Subject: RE: Planning Consultation on: BE/148/20/OUT

Engineers comments in respect to surface water and land drainage;

Application No:	BE/148/20/OUT
Registered:	9th December 2020
Site Address:	Nursery Fields Land to the North of Chalcraft Lane West Bersted PO21 5TS
Grid Reference:	491599 100730
Description of Works:	Outline application with some matters reserved to provide up to 225 residential units with associated infrastructure, open space and vehicular and pedestrian access. This application affects a Public Right of Way.

Submitted Parameter Plan – drawing reference 01304_Green Infrastructure Parameter Plan_PP_02_P1

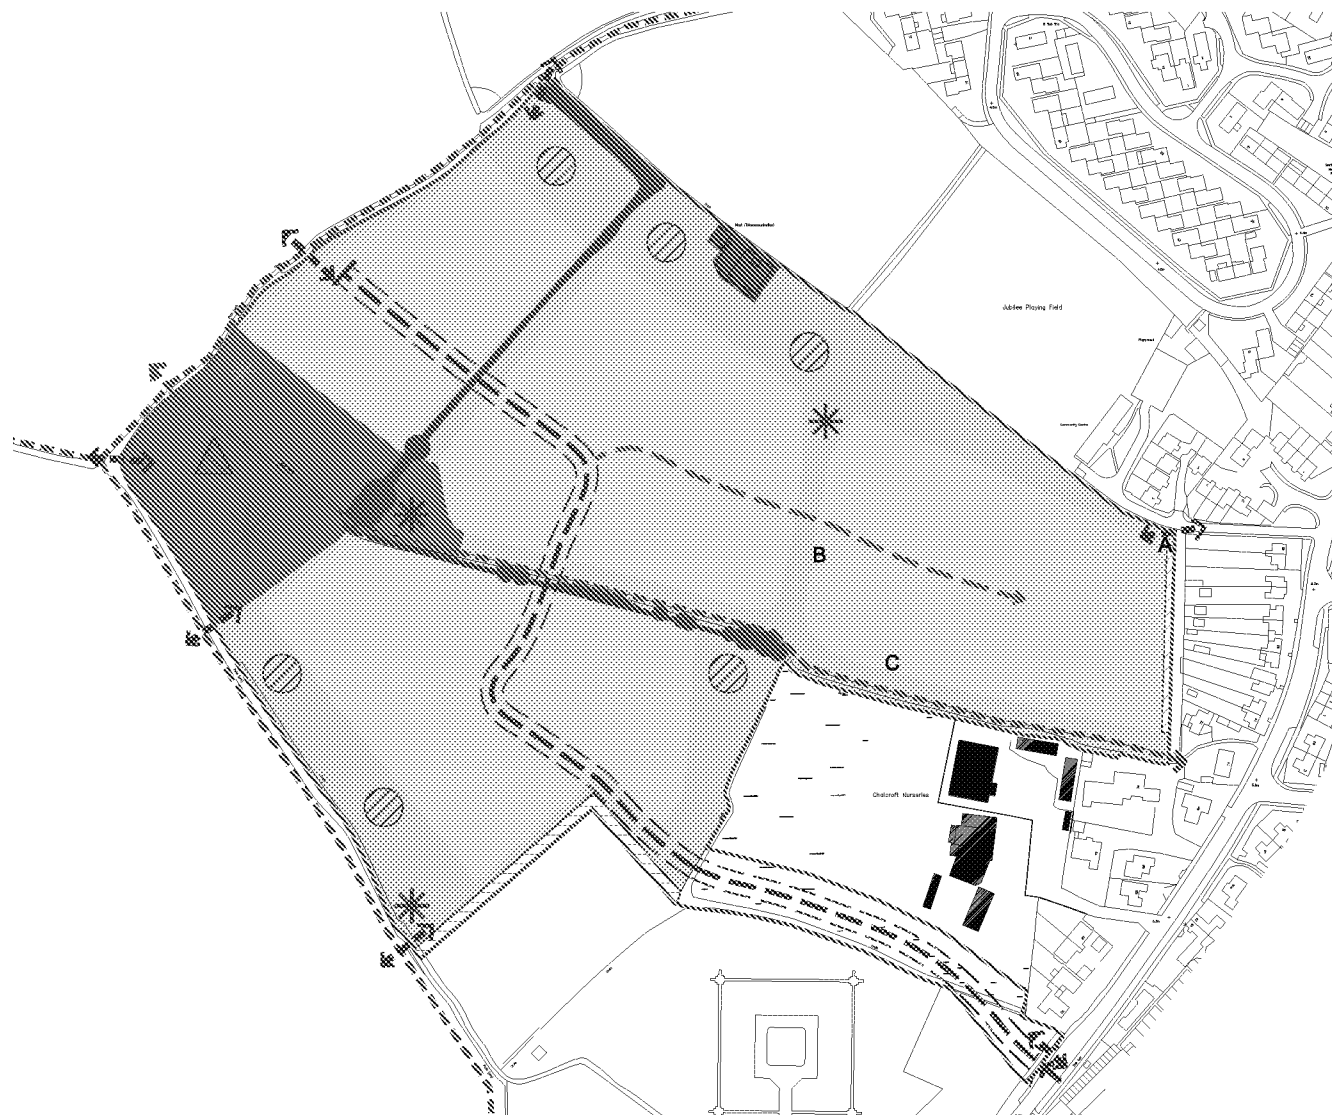
Numerous watercourses pass through the site and around its perimeter. The layout has accounted for these and the applicant will need to ensure that all structures/ponds, etc are kept at least 3 metres from the top of any ditch bank. Modifications will be required to some watercourses in order to facilitate vehicular and pedestrian access crossings. Improvements will also be required to existing ditches and culverts, including the existing culvert in the north west corner of the site. Land Drainage Consent will be required for these works.

Although it is recognised that surface water disposal is going to rely on restricted discharges to watercourses, Infiltration must be utilised where ever possible. It is noted that summer infiltration testing was carried out at variable depths which indicated borderline rates, however, for design purposes shallow winter infiltration (to be carried out January/February) testing is required at depths dictated by the winter groundwater monitoring, ensuring no testing takes place below recorded peak groundwater levels. The testing locations will also need to cover the entire site, not just the pond locations, as previously undertaken, to account for other potential suds features ie. permeable paving/swales, etc. The applicant is urged to discuss these requirements further.

Catchment areas connecting to watercourses must mimic existing catchments. Rates to be restricted to Qbar (based upon the developed impermeable area). Where restricted flow rates are less than 2 litres per second and hence the

flow control device is at greater risk of blockage, there may be the need to reduce the number of proposed outfalls in order to increase the flow control diameter (whilst respecting existing catchments). Alternative measures include upstream filters but these are not the preferred option.

All aspects of the SUDS must respect any root protection zones associated with existing trees/proposed trees at maturity.
